**City of Albuquerque**  
P.O. BOX 1293 ALBUQUERQUE, NEW MEXICO 87103

RE: Performance Bond - Private Street Improvements for Armijo &  
Brothers Addition Subdivision

RE: FRUIT ST. DOWNTOWN HOUSES DRAINAGE PLAN

I have reviewed the referenced drainage report and forward the following comments:

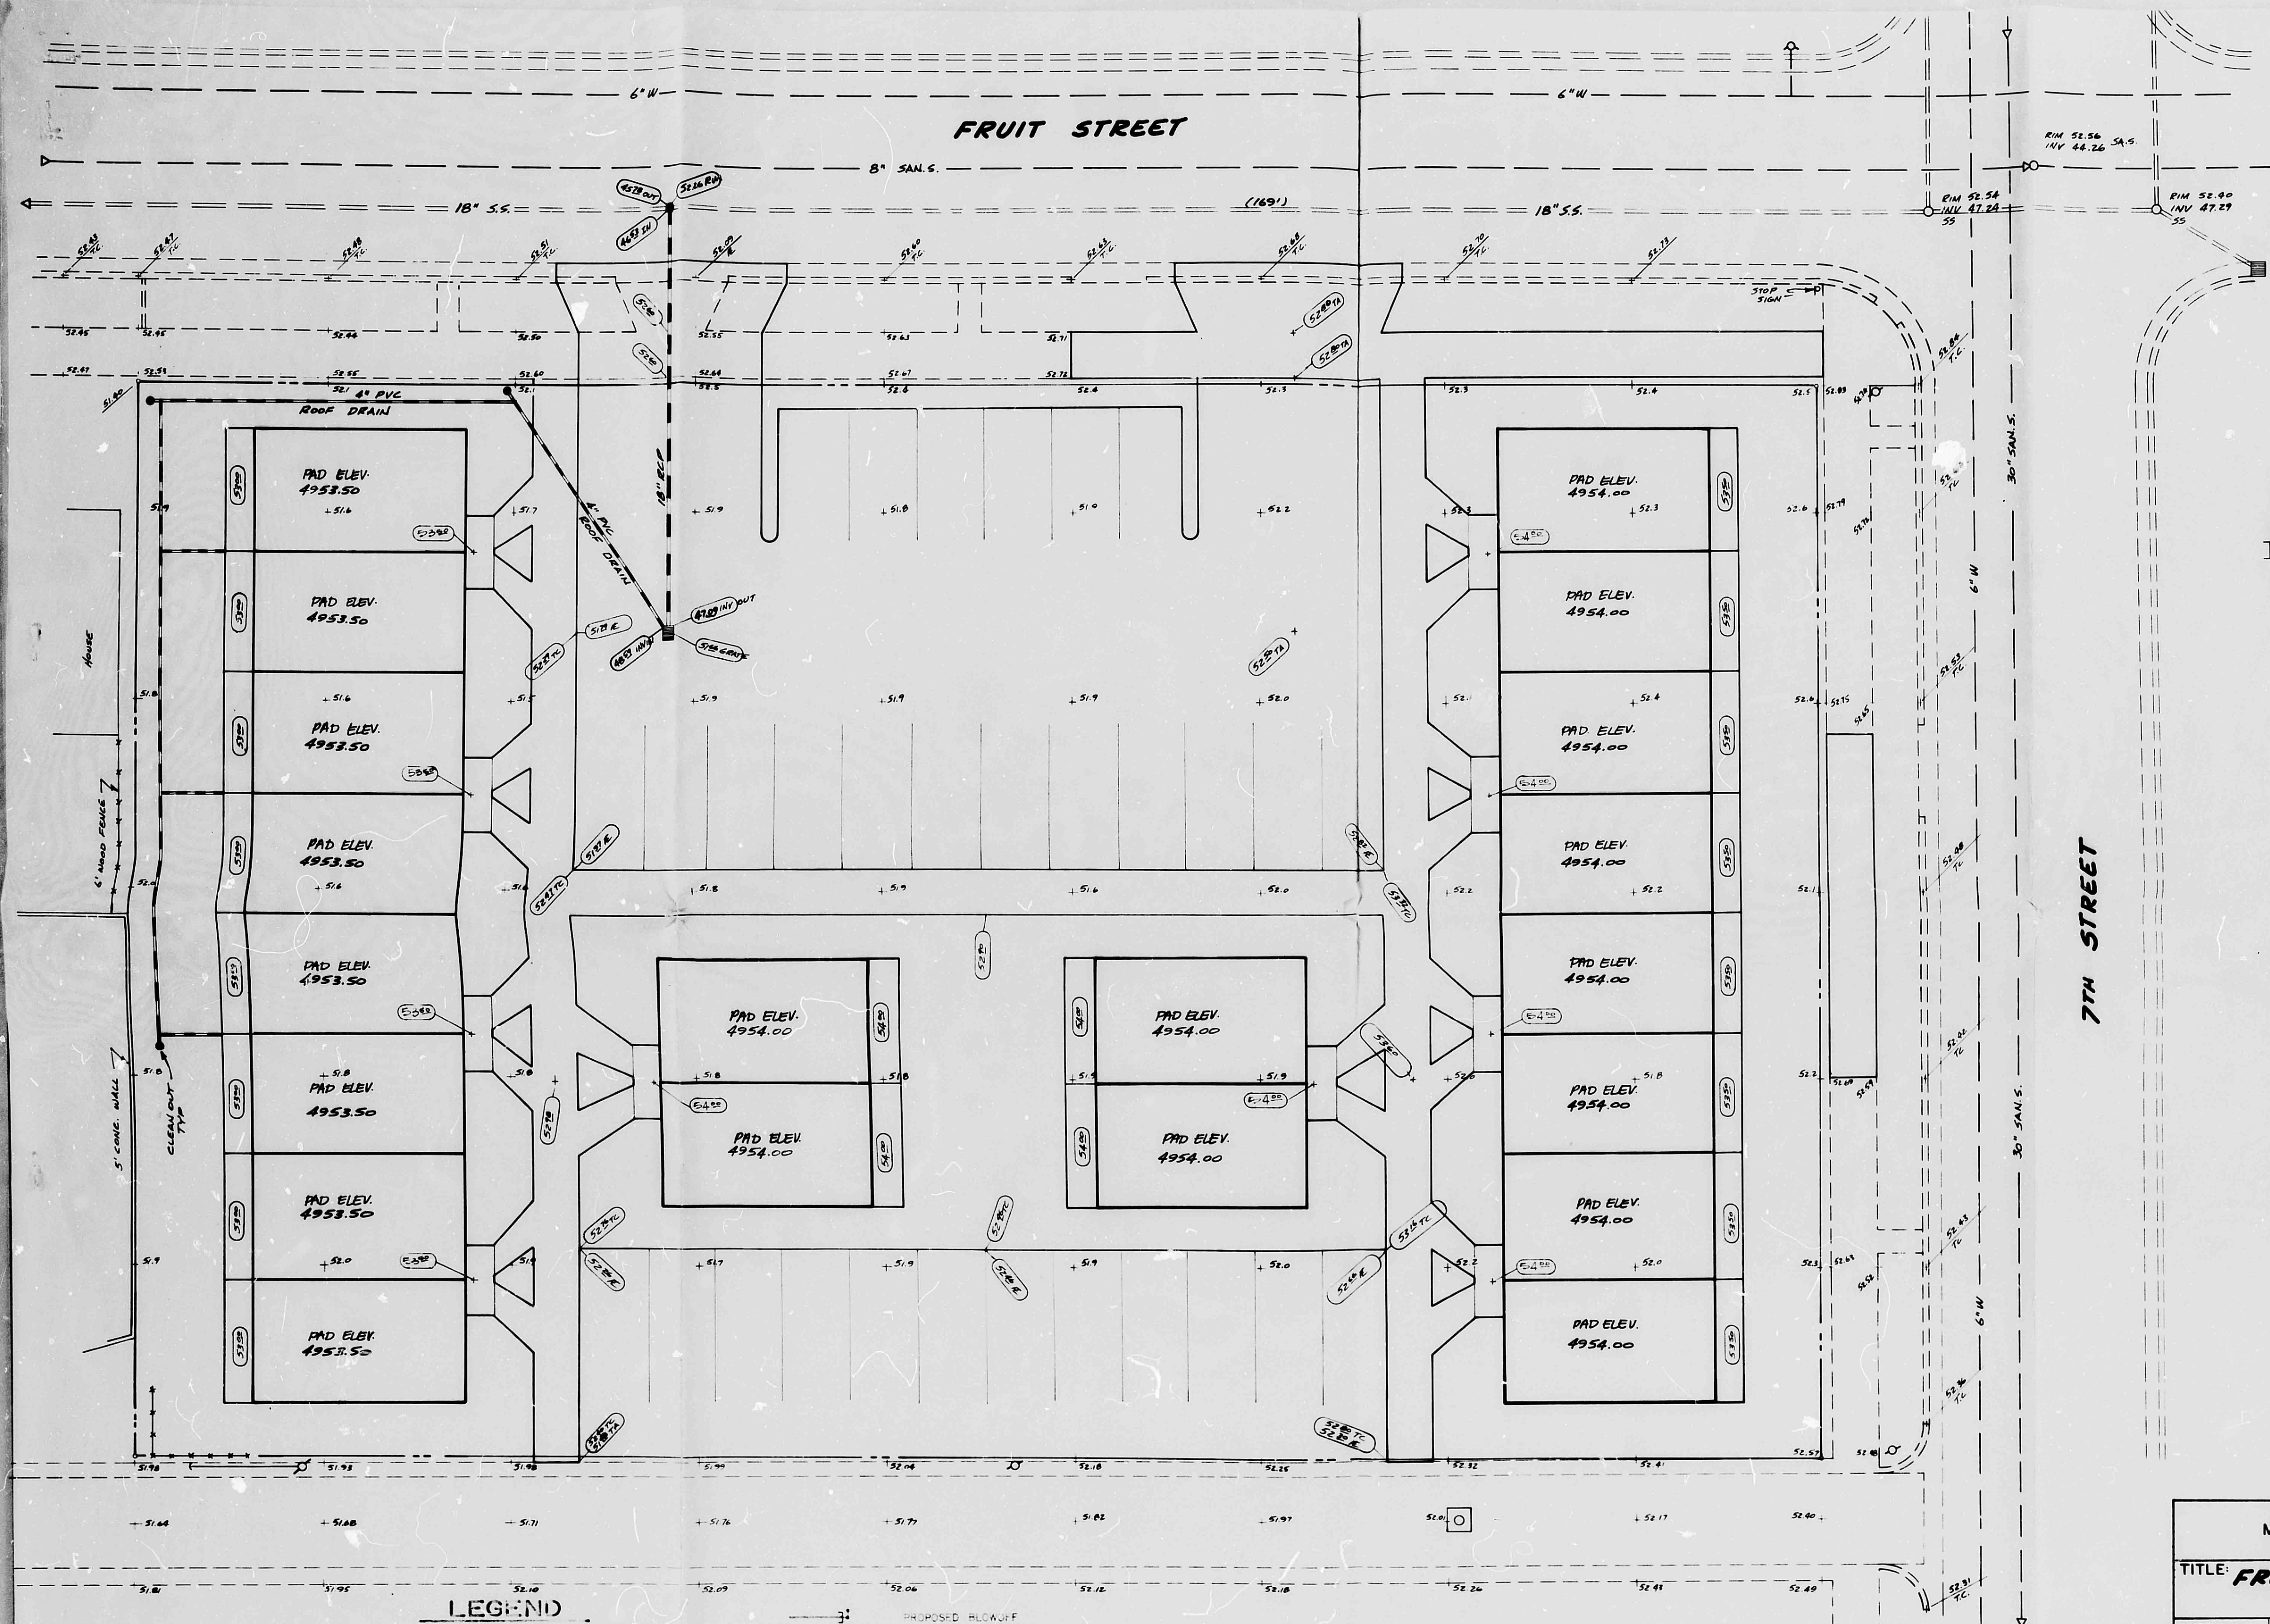
- a. Please clarify how the 4" PVC roof drain will operate and include backup calculations. Why aren't all the units along the west property line connected to the system?

- b. What provisions have been made for maintenance and cleanout of the system? Will clogging of the pipe be an ongoing problem?
- c. Could the runoff generated by Area C be routed through a swale and into the parking area?

- d. How is runoff directed from the units into the parking area and alley? Details for routing the runoff internal to the site should be provided.
- e. What is the maximum runoff volume that can be stored in the parking area if the storm drain system plugs?

- f. Due to the unpredictable nature of the valley storm-sewer system, the runoff from the site must be discharged at a controlled rate.
- g. Approved copies of Special Order No. 19 must be attached to the City Construction sets before a building permit is issued.

The townhomes in this project have an alternating roof line; flat, pitched, flat, etc., therefore, on the west row of homes we are going to provide an underground roof drainage system, maintained by the Home Owners Association to preserve the usable rear yard required by FHA, and prevent offsite flow into neighboring property.

The other homes roof drainage will be carried through roof gutters or canals and be discharged into the respective areas as shown on the drainage plan. The exact location of the canals and downspots will be provided on the architect's building plans.

The maximum runoff volume that can be stored in the parking area if the storm drain plugs is approximately 1,365 cubic feet. See special order 19 for the orifice plate to control the discharge into the valley storm-sewer system.
